From: Teske, Mark S (DFW) <Mark.Teske@dfw.wa.gov>
Sent: Tuesday, October 29, 2013 4:58 PM
To: Jeff Watson
Subject: LP-12-00001 Reecer Ranch
Attachments: P1070086.JPG; P1070091.JPG; P1070094.JPG; SKMBT_C28013102916580.pdf

Attached are pictures of flood waters that involve significant portions of the proposed plat taken during January of 2009. The first attached photograph ending 086 is at the Dry Creek connection at the downstream end of the proposed plat. The other two pictures are from Dry Creek Road at the upper end of the proposed plat. We are concerned that the proposed stream buffer fails to adequately consider the flood issue inherent to this location.

RECEER RANCH PLAT
 A PORTION OF THE EAST 1/2 OF SECTION 28,
 TOWNSHIP 18 NORTH, RANGE 18 EAST, W.M.,
 KITITAS COUNTY, WASHINGTON

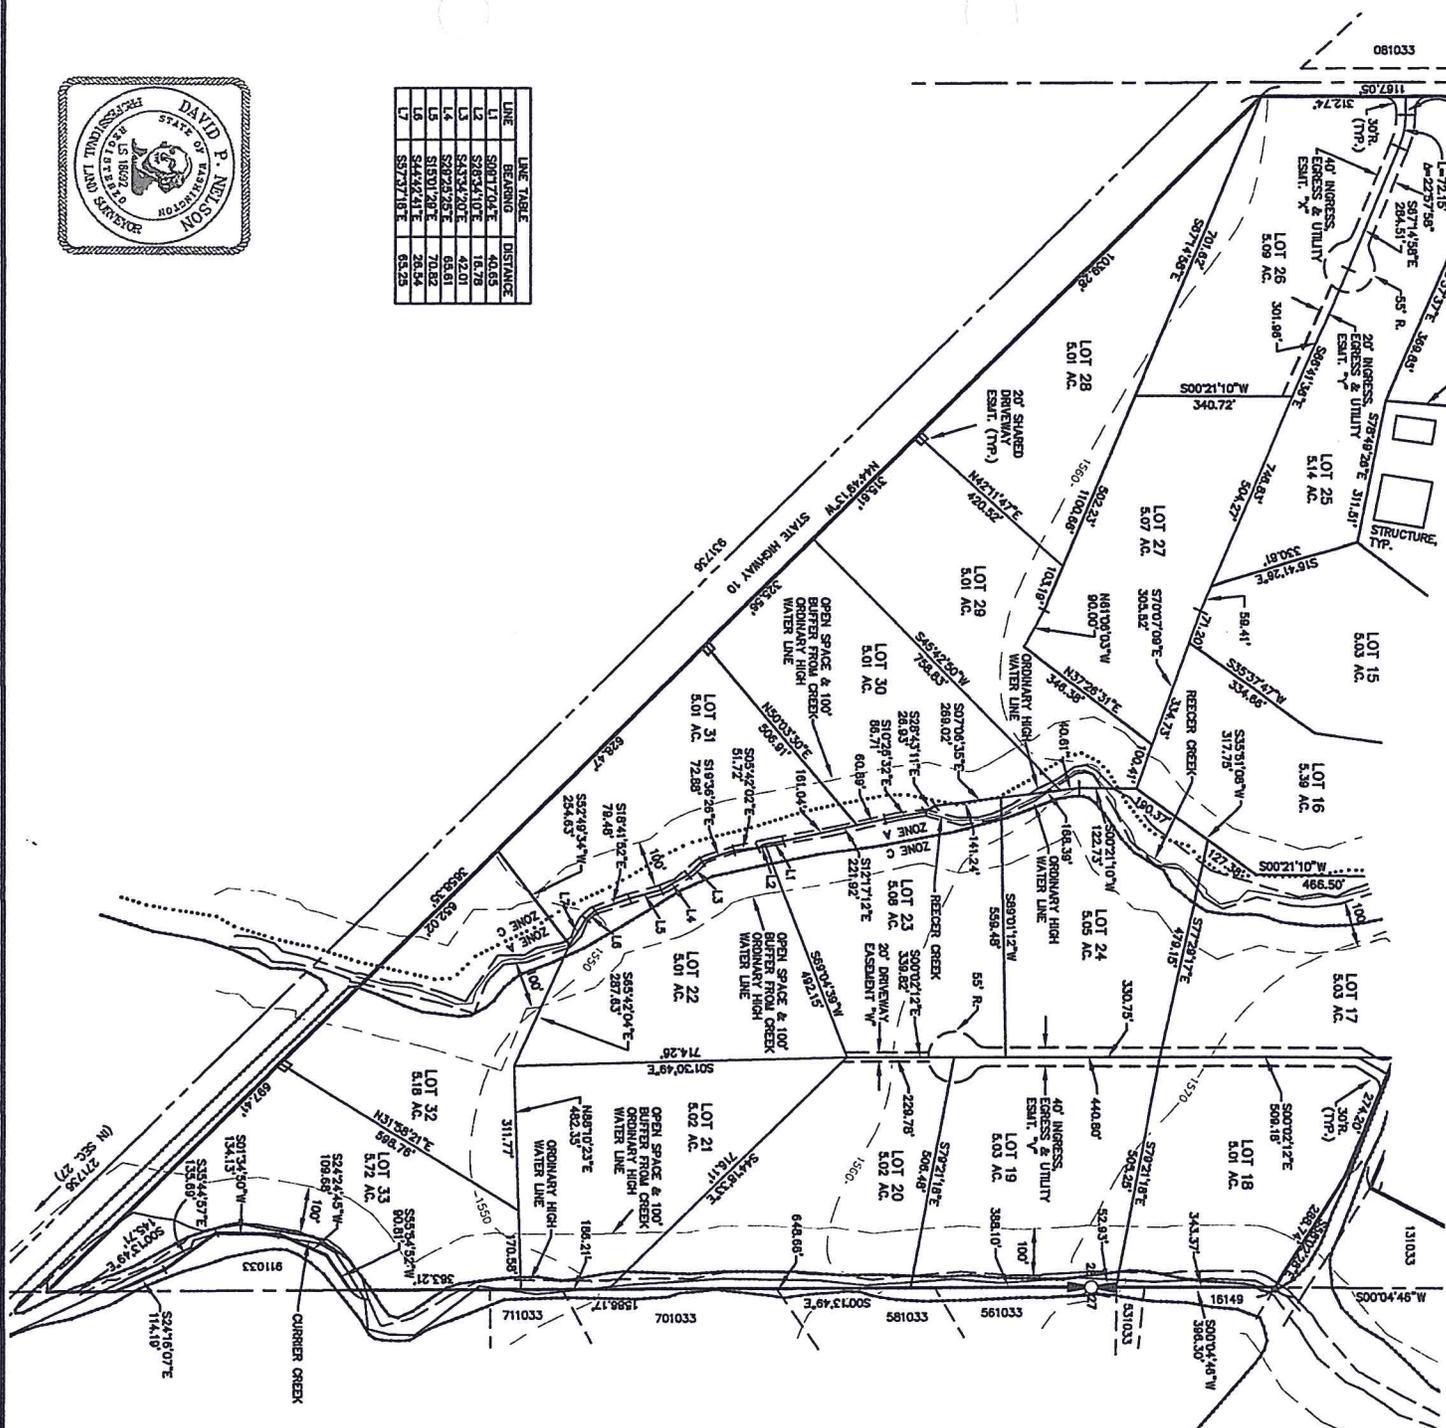
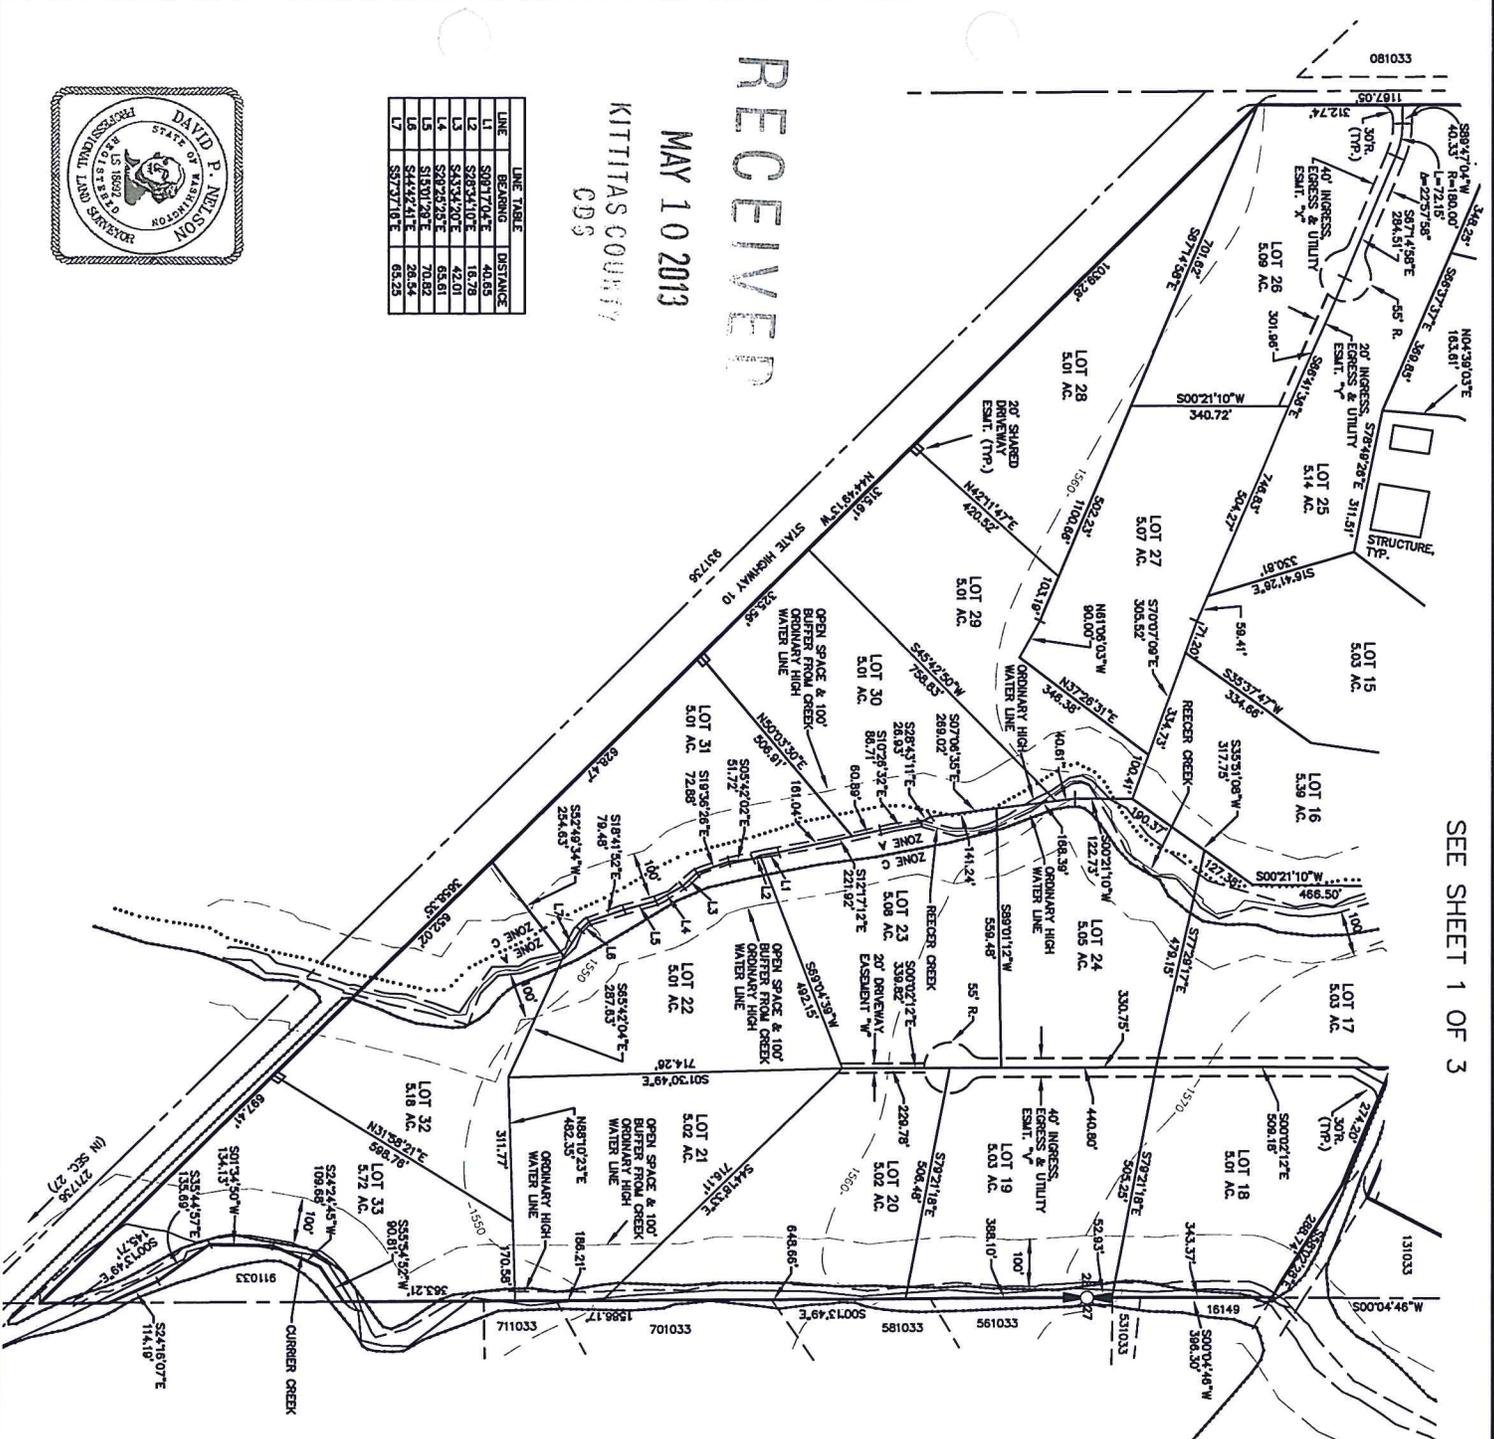
Both Reecer and Currier Creek are used by anadromous fish (coho salmon and mid-columbia steelhead). Significant effort and public funds have been invested in restoration work in the Reecer-Currier creek system. The proposed 100-ft stream buffer is less than needed based upon the best available science. Additional width is needed to provide for a riparian zone that will restore/maintain in-stream habitat for salmon and trout and provide adequate floodplain storage.

We are concerned that the county does not prevent the construction of levees in developments. The adjacent Currier Creek Estates project constructed a levee along the creek (which persists to this day and directs additional flood waters on the proposed plat). There is no assurance that the current proposal will not result in levees similarly constructed along the edge of the stream to prevent flooding of the residences that are proposed for areas known flooding.
